CONSTRUCTION PLANS FOR T.F. STONE BUILDING ADDISON STORAGE ADDITION LOT 1, BLOCK A

*Reviews
SZ & P.L.
1/20/03*

T.F. STONE COMPANIES, INC.
T.F. STONE BUILDING
LOT 1, BLOCK A, ADDISON STORAGE ADDITION
PAVING AND DIMENSIONAL CONTROL PLAN
ADDISON, DALLAS COUNTY, TEXAS

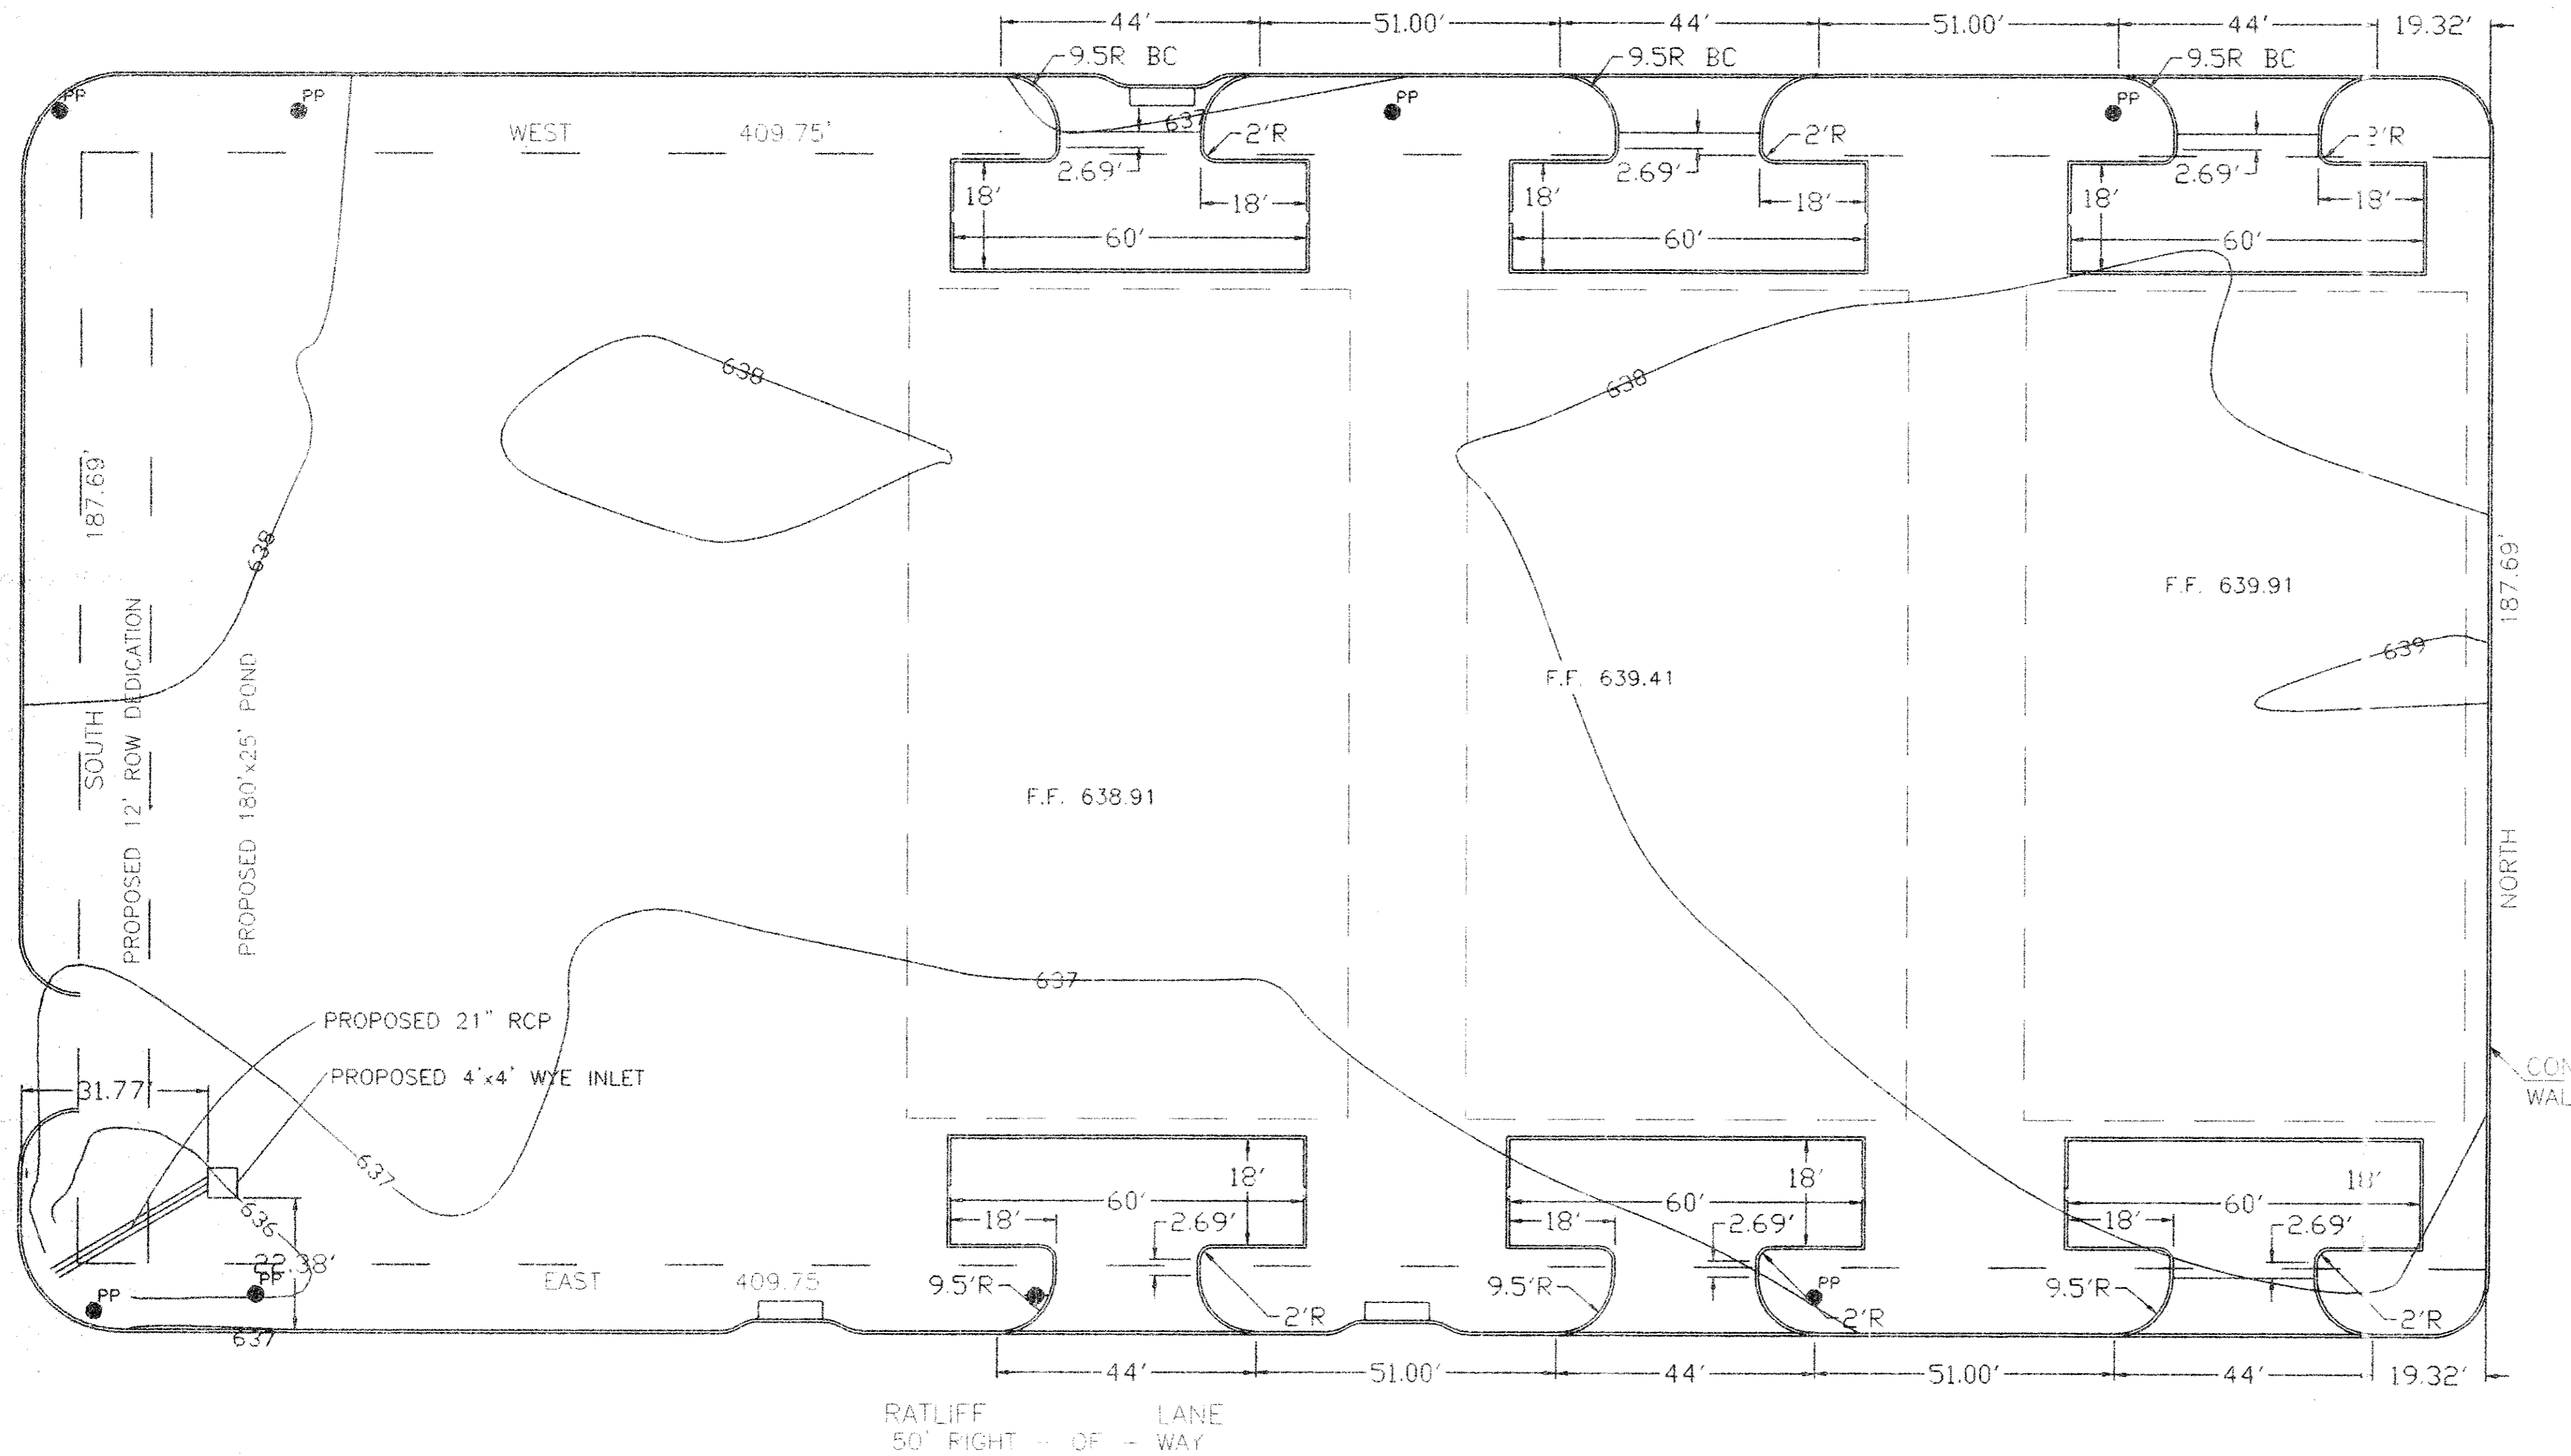
Handwritten note:
EITHER EXTEND THE
SIDEWALK AROUND
AS SHOWN, OR PLACE
ADA RAMP!

Handwritten note:
We need to look at
how we want the
ramps to look here.
There will be some curbs
removed.
